**ExQ2: 03 August 2021****Responses due by Deadline 7: 03 September 2021**

| <b>ExQ2</b>  | <b>Question to:</b>                           | <b>Question:</b>  |
|--|---|---|
| <b>DCO.2 Draft Development Consent Order (DCO) – comments on the Applicants’ responses to ExQs1 (all para numbers are prefixed DCO.)</b> |   |   |

SECTION B - B
SCALE 1:200

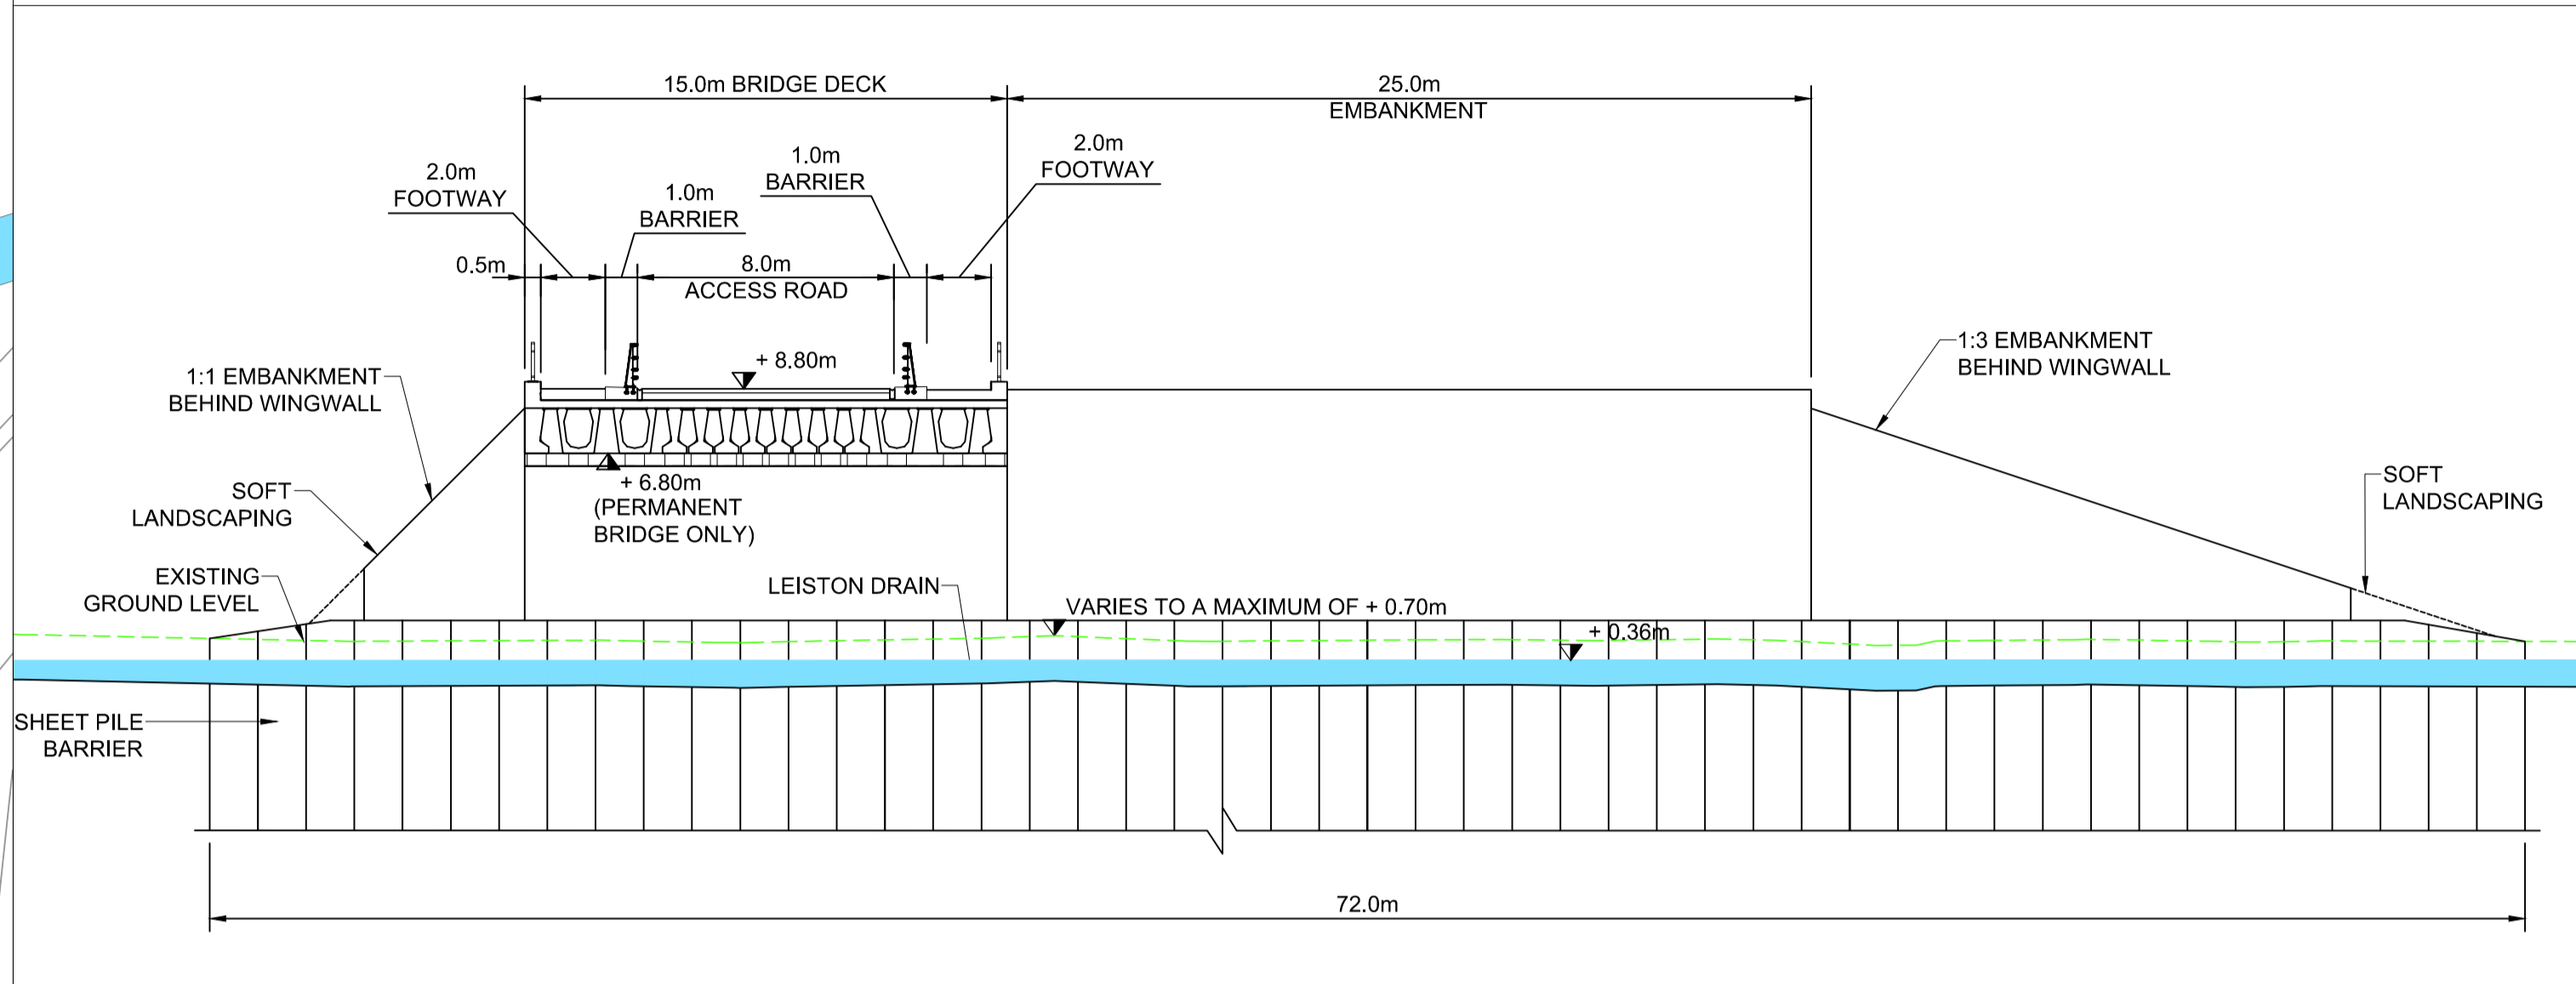
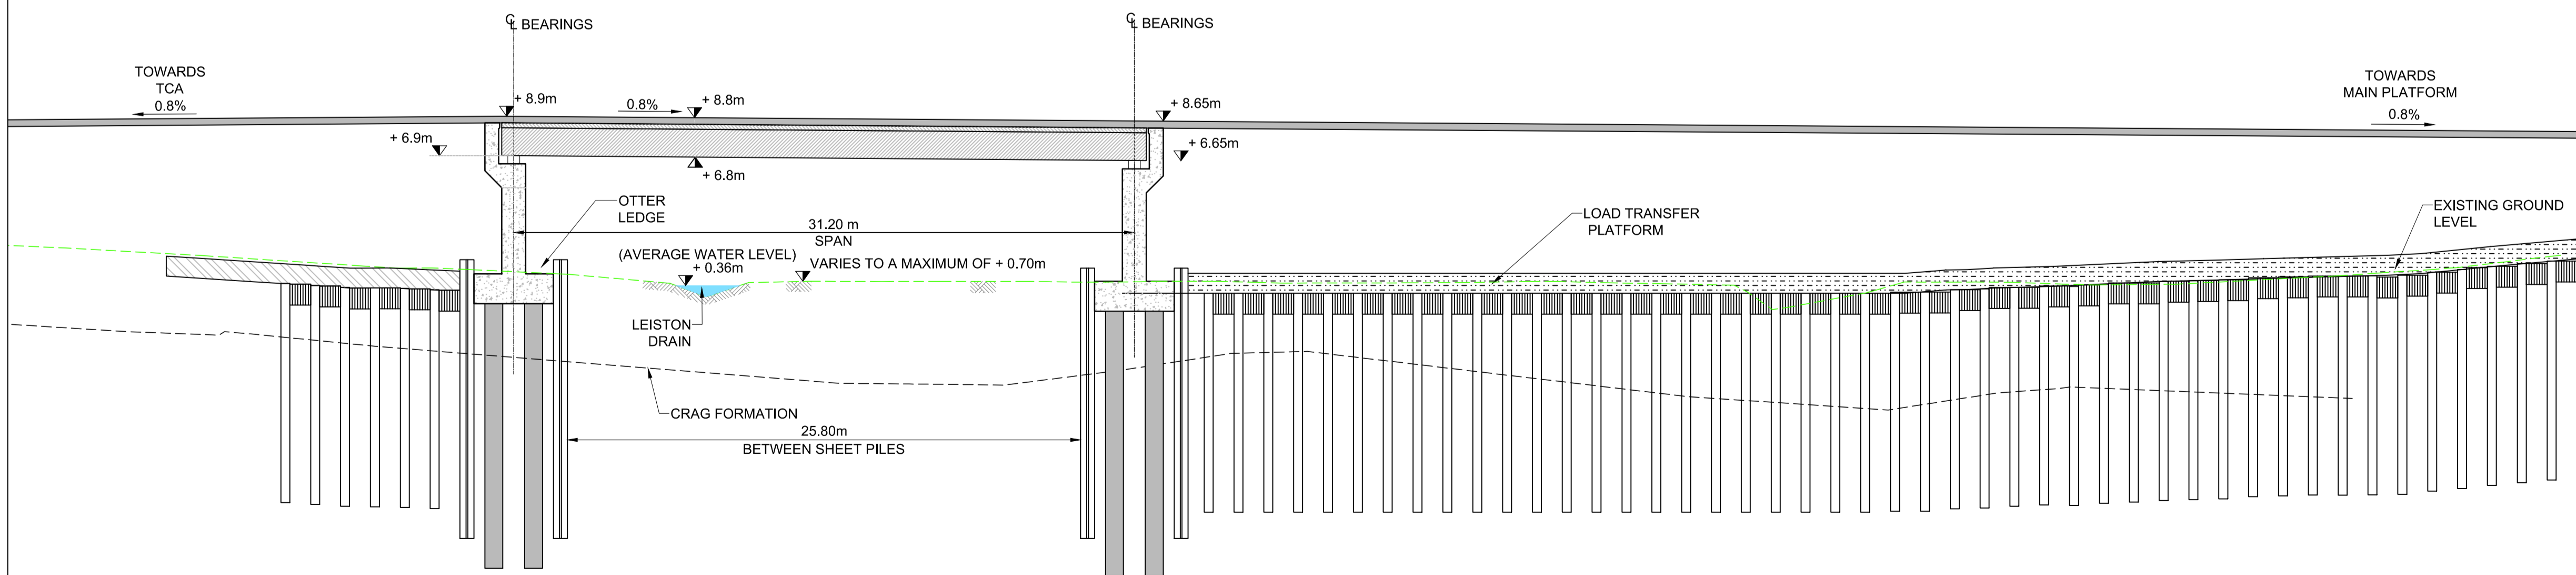
| <b>ExQ2</b> | <b>Question to:</b>  | <b>Question:</b>   |
|-------------|--|--|
| LI.2.7      | ESC, SCC, Natural England, The AONB Partnership, Stop Sizewell C, TASC | <p><b>SSSI Crossing – Design Amendment</b></p> <p>Please review the amended SSSI crossing design [REP5-010] and provide comment.</p>   |
|             | TASC response  | <p>TASC preface our comments on the SSSI crossing with our overriding opinion that the access road planned, results in too great a loss of AONB and SSSI. TASC remind the ExA that while Sizewell was listed within EN6 as a potentially suitable site, we draw attention to TASC's ISH 5 Landscape submission [REP5-296] para 15d) which says, in respect of EN6 Annex C [para C.8.69]: "The assessment expressly excluded consideration of the access road impact, indeed it says: "there is no presumption that development will take place in the area of the access road". It is the access road that results in the need for the SSSI crossing and the loss of SSSI within the AONB. Loss of SSSI cannot be said to enhance the purpose of the AONB's designation nor help with wildlife recovery.</p> <p>Regarding the SSSI crossing design in REP5-010, whilst little information is provided, the illustrations reinforce TASC's opinion that the structure is totally at odds with the setting and attributes of the AONB. The embankments have a man-made appearance so do not accord with the natural beauty of the landscape. TASC refer to EN1 para 5.9.9 which states "AONBs have been confirmed by the Government as having the highest status of protection in relation to landscape and scenic beauty." This is confirmed in the NPPF at para 176.</p> |

| <b>ExQ2</b> | <b>Question to:</b>  | <b>Question:</b>   |
|-------------|--|--|
| LI.2.8      | The Applicant  | <p><b>SSSI Crossing – Design Amendment</b></p> <p>Please confirm what assessment has been undertaken in respect of potential landscape and visual impact(s) due to the amended design of the SSSI crossing [REP5-010]. In addition, please provide visualisations which clearly depict the proposed sheet pile barrier.</p>  |
